From: Louise Bearcroft
Sent: 11 March 2026 11:18
To: DC Admin
Subject: FW: Planning ref 2025/92713

From:
Sent: 16 February 2026 15:35
To: Louise Bearcroft <Louise.Bearcroft@kirklees.gov.uk>
Subject: Planning ref 2025/92713

I wish to comment on the recent changes re this planning application:-

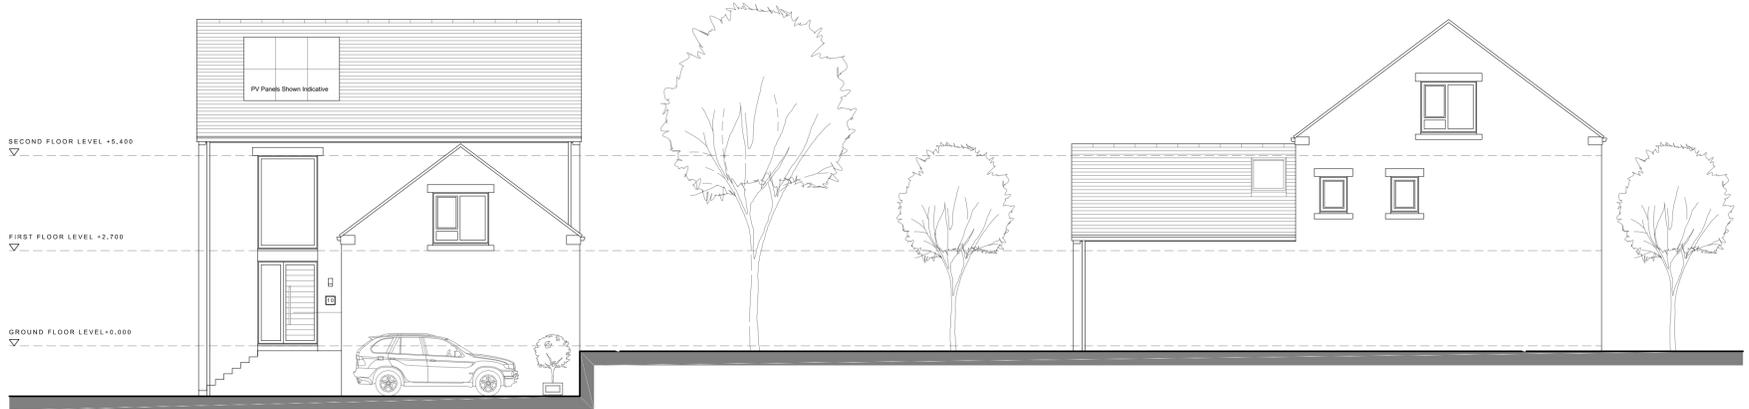
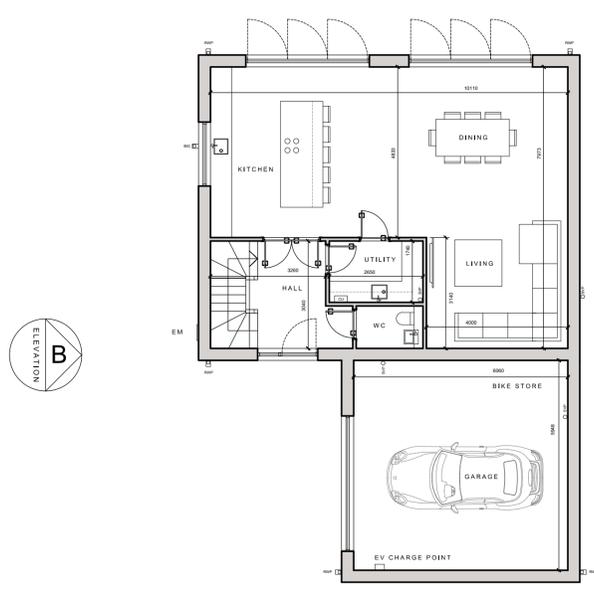
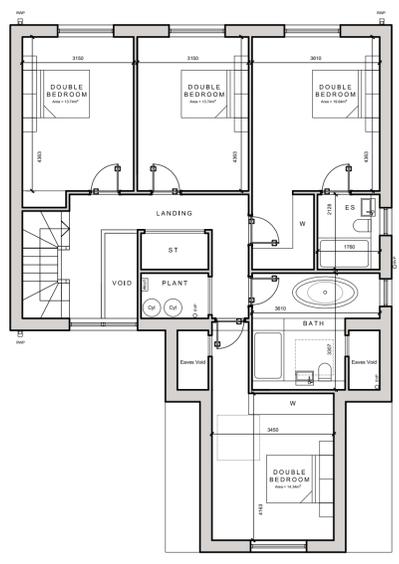
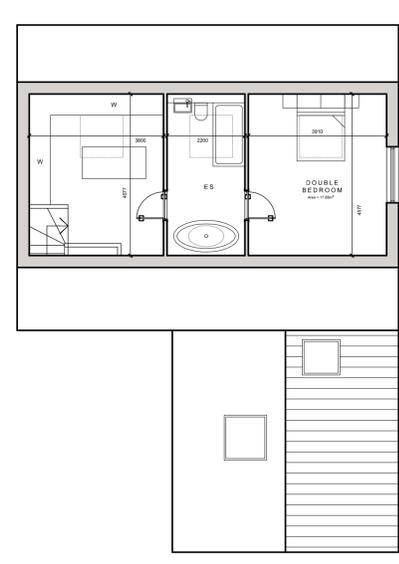
Plots 1 and 10 are the most contentious dwellings. They still show as 5 bed houses (plot 1 is 3 storey) but they should be 2 storey smaller 4 bed houses as per the outline pp granted in 2023.

Plot 1 originally had a house area of 161.4 sq m on outline pp in 2023 but this has increased to 225.21 sq m excluding garage in 2025.

PLOT 2

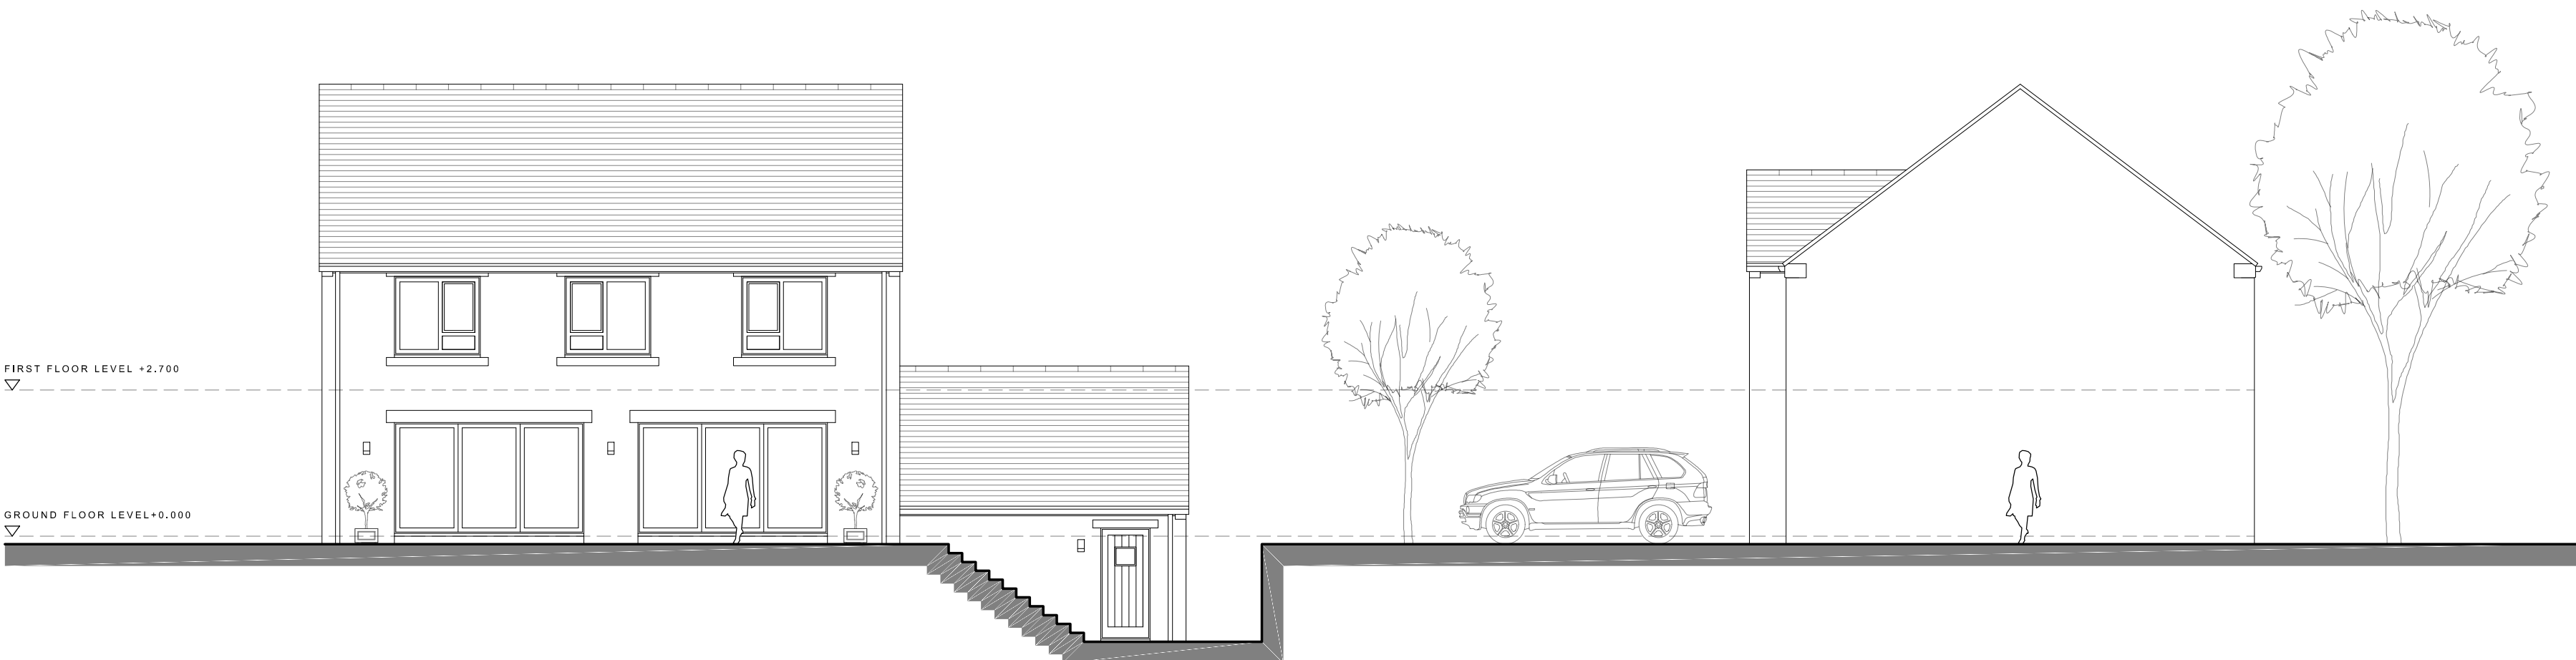
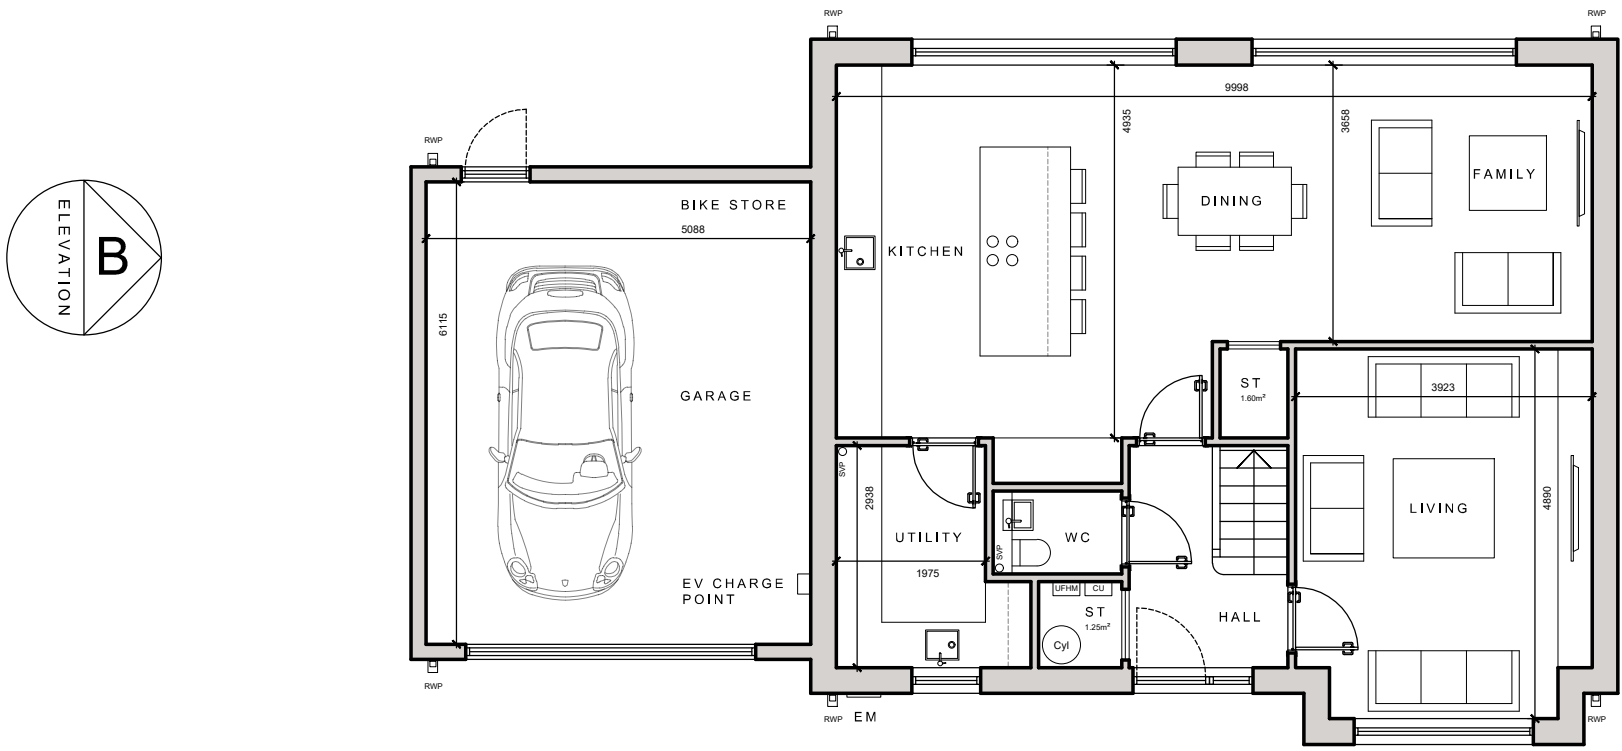
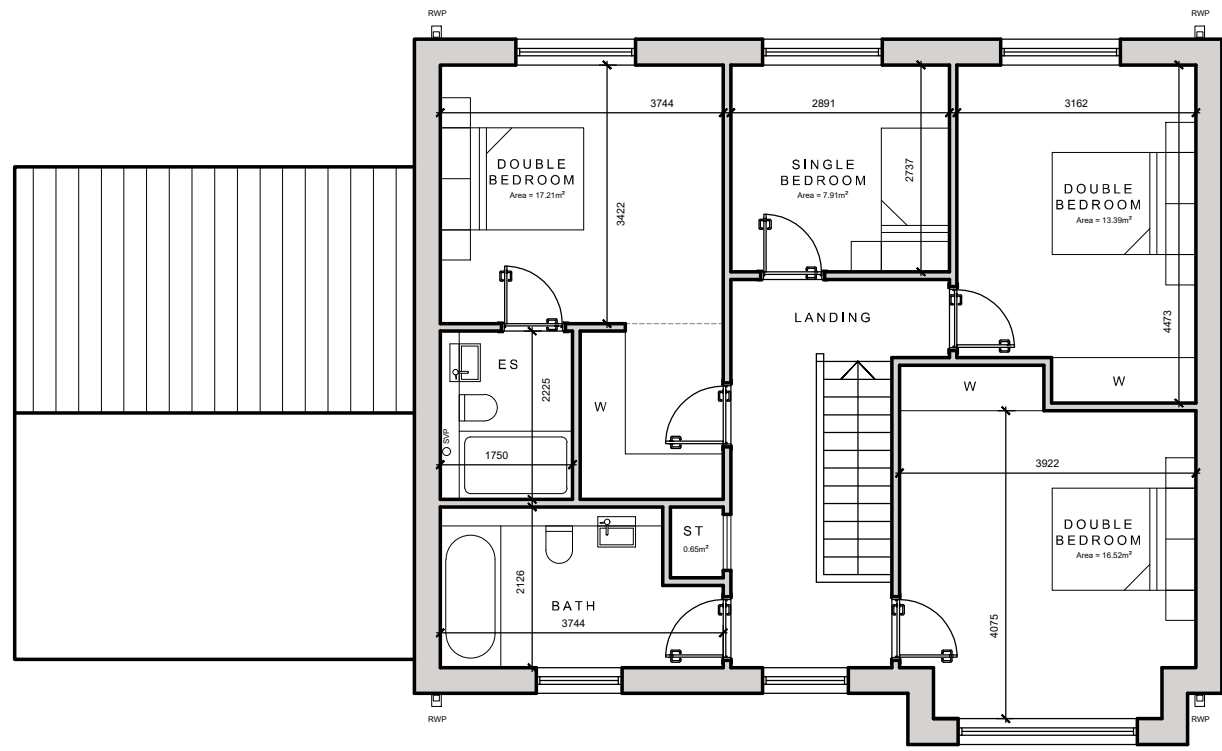
Plot 2 was 161.4 sq m in 2023 and now 163.48 sq m excluding garage in 2025.
